# CITY OF ALBUQUERQUE

**Re: Tam Le Salon  
130 Coors Blvd NW  
Grading and Drainage  
Engineers Stamp Date 8/10/2015 (K10D047)**

**Re: Tam Le Salon  
130 Coors Blvd., NW  
Traffic Circulation Layout  
Engineer's/Architect's Stamp dated 8-10-15 (K10-D047)**

TRAFFIC NOTES:

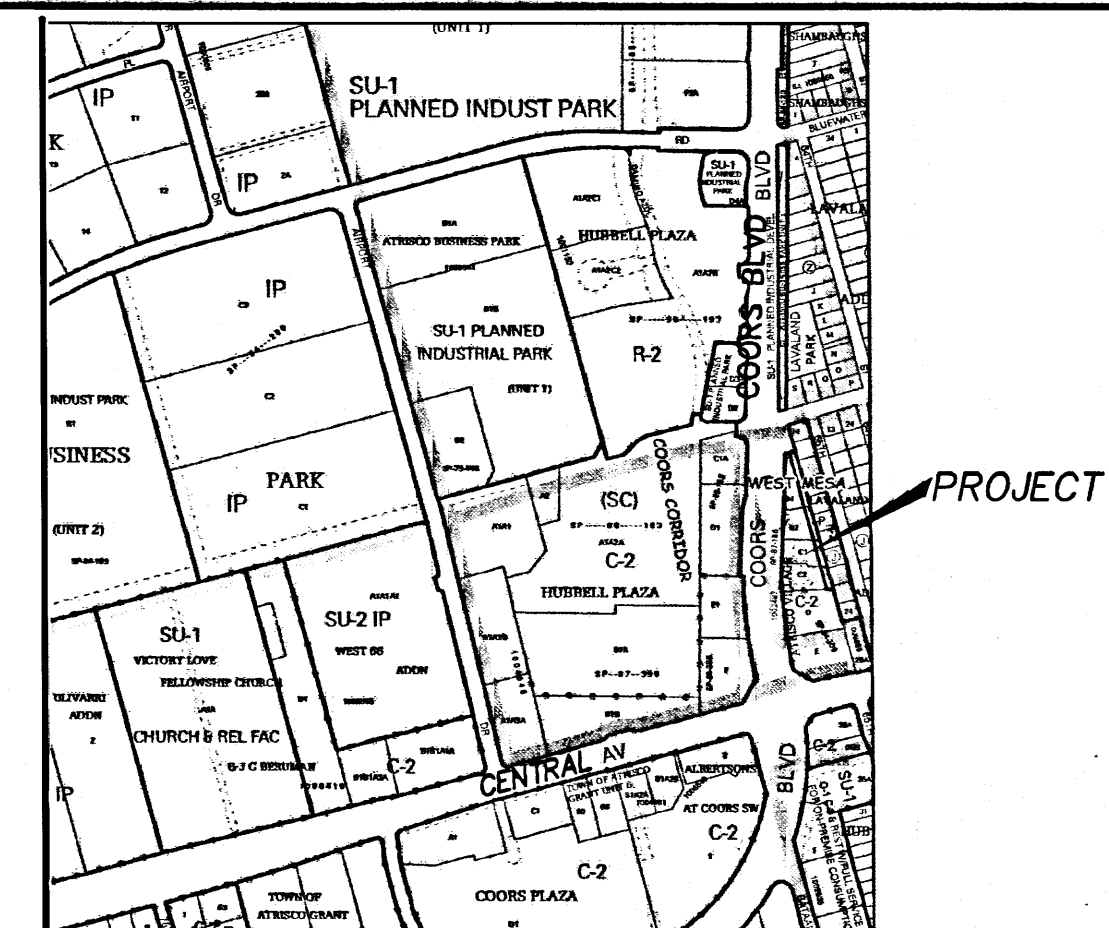
1. Identify and dimension the medians and curb cuts on Coors Blvd. for the proposed building and the existing building to the south. If there are to be no new curb cuts for the proposed building, please detail access pathway from the adjacent property's drive pad on drawing.

2. Show all drive aisle widths and radii for the proposed building off of Coors Blvd.
3. Per DPM, the handicap parking spaces are to be a min. of 8.5 ft. wide and 20 ft. in length and there must be 6 ft. clear pedestrian pathway provided to building entrance. Per the submitted drawing, the ADA parking is 18 ft. in length with wheel stops and overhang, for a max. of 16 ft. in length.

5. Per the DPM, a 6 ft. wide ADA accessible pedestrian pathway is required from the public sidewalk to the building entrances. Please clearly show this pathway and provide details of ADA ramps from Right Of Way.

7. Please provide a sight distance exhibit (see the *Development Process Manual*, Chapter 23, Section 3, Part D.5 Intersection Sight Distance). Please provide this detail, if a drive pad is to be constructed on Coors Blvd.

8. Please add the following note to the clear sight triangle: "Landscaping and signage will not interfere with clear sight requirements. Therefore, signs, walls, trees, and shrubbery between 3 and 8 feet tall (as measured from the gutter pan) will not be acceptable in this area."
9. Please specify the City Standard Drawing Number when applicable.
10. Please include a copy of your shared access and parking agreement with the adjacent property owner.
11. Work within the public right of way requires a work order with DRC approved plans.
12. Please include two copies of the traffic circulation layout at the next submittal.

Regarding comment #3 - Standard parking space size comment is confusing to read. Furthermore, the Zoning Code states by definition that 8.5' X 18' is acceptable - please reference Ch.14, Art. 16-3-1, "Off-Street Parking Reqs" and "*Automobile and Light Truck Space Standards*", paragraph F, which references back to 14-16-1-5 "Definitions", Parking Space. The DPM (Ch. 23) currently being updated should be revised to be consistent with the zoning code.

Additionally, I have noticed that "standard" TCL comments are inserted into your comment letters, even when those specific concerns are addressed on the plans - please see #2, 4, 5, 7 (not applicable since a D.Pad is not being constructed), 8, 9, 10 (as stated verbally to you that access easement maintenance/beneficiary clearly stated on the 2003 plat which was included in the original electronic file).

11. A small portion of a flush 6' sidewalk (without ramps) will be constructed w/in the Coors Blvd R.O.W. - I do not feel this would require a W.O.

## GRADING & DRAINAGE PLAN

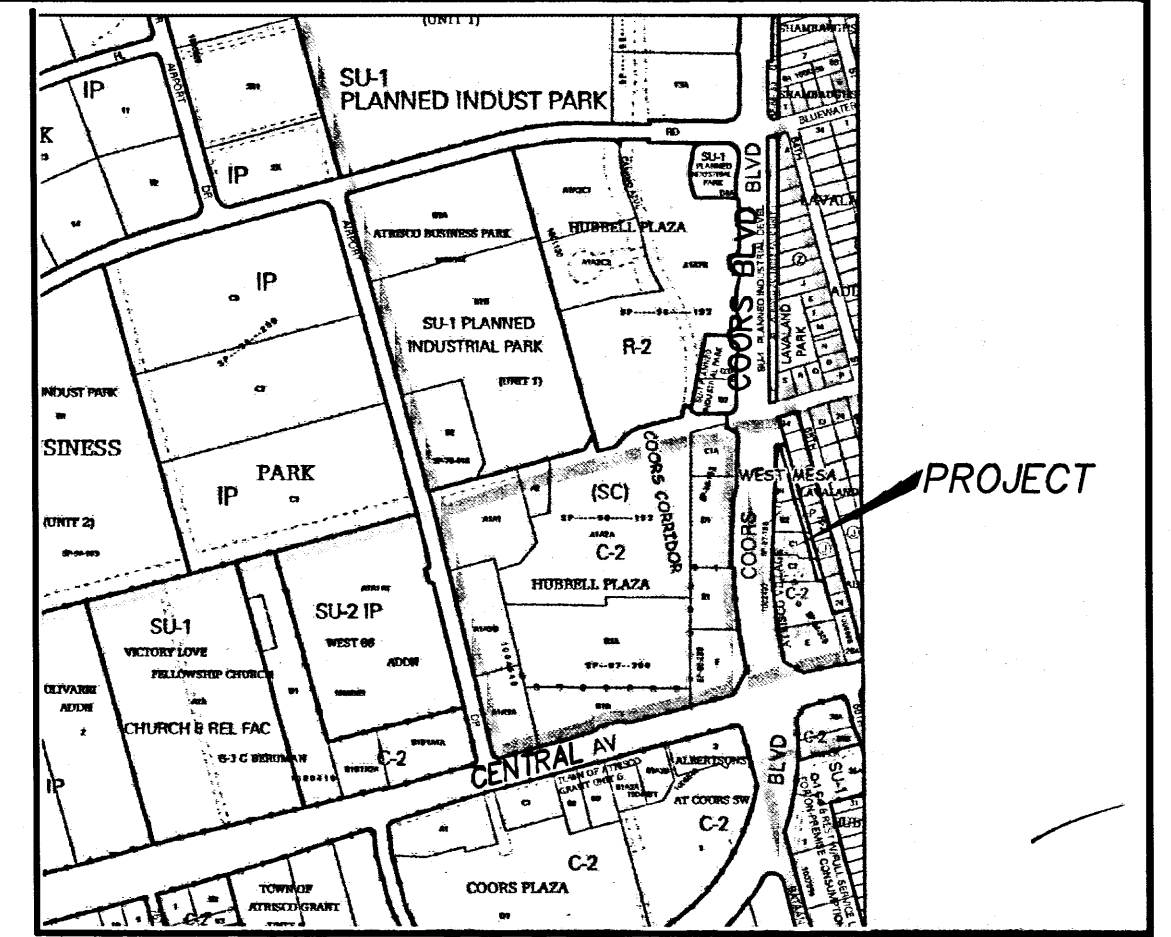
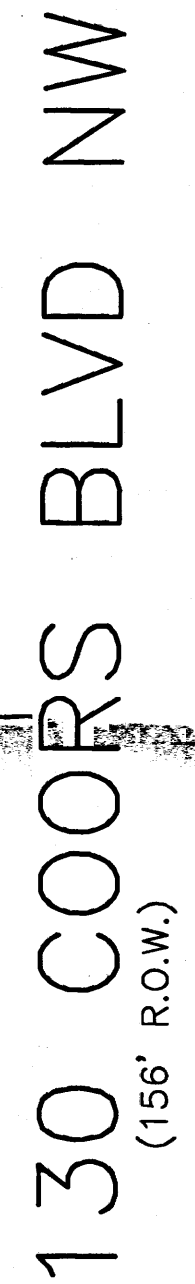
- Provide roof flows.
- Provide flow calculations for the concrete drainage rundown.
- Verify if the system in the sidewalk is a sidewalk culvert or pvc? Provide calculations for either one.
- An access agreement must be provided from the owners to the south.

- The roof drainage is to the North. The channel conveys runoff to two-1.75' wide existing sidewalk culverts along Coors.. Channel Calcs:

Shape ..... Rectangular  
Solving for ..... Flowrate  
Slope ..... 0.0030 ft/ft  
Manning's n ..... 0.0130  
Depth ..... 0.50 ft  
Height ..... 0.50 ft  
Bottom width ..... 4.00 ft

Flowrate ..... 6.7979 cfs  
Velocity ..... 3.3989 fps  
Full Flowrate ..... 6.7979 cfs.....>> estimated Q100 = 3.36 CFS (Both C-1& C-2)  
Flow area ..... 2.0000 ft<sup>2</sup>  
Flow perimeter ..... 5.00 ft  
Hydraulic radius ..... 0.40 ft  
Top width ..... 4.00 ft  
Area ..... 2.0000 ft<sup>2</sup>  
Perimeter ..... 5.00 ft  
Percent full ..... 100.00 %

The SDWK Culverts are calced, using -2.9% slope @ 3.5' Wide and 0.5' depth:

Shape ..... Rectangular  
Solving for ..... Flowrate  
Slope ..... 0.0290 ft/ft  
Manning's n ..... 0.0130  
Depth ..... 0.30 ft  
Height ..... 0.58 ft  
Bottom width ..... 3.75 ft

Flowrate ..... 8.8893 cfs.....>>>>>> 3.36 cfs (above)  
Velocity ..... 7.9016 fps  
Full Flowrate ..... 24.6029 cfs  
Flow area ..... 1.1250 ft<sup>2</sup>  
Flow perimeter ..... 4.35 ft  
Hydraulic radius ..... 0.26 ft  
Top width ..... 3.75 ft  
Area ..... 2.1750 ft<sup>2</sup>  
Perimeter ..... 4.91 ft  
Percent full ..... 51.72 %
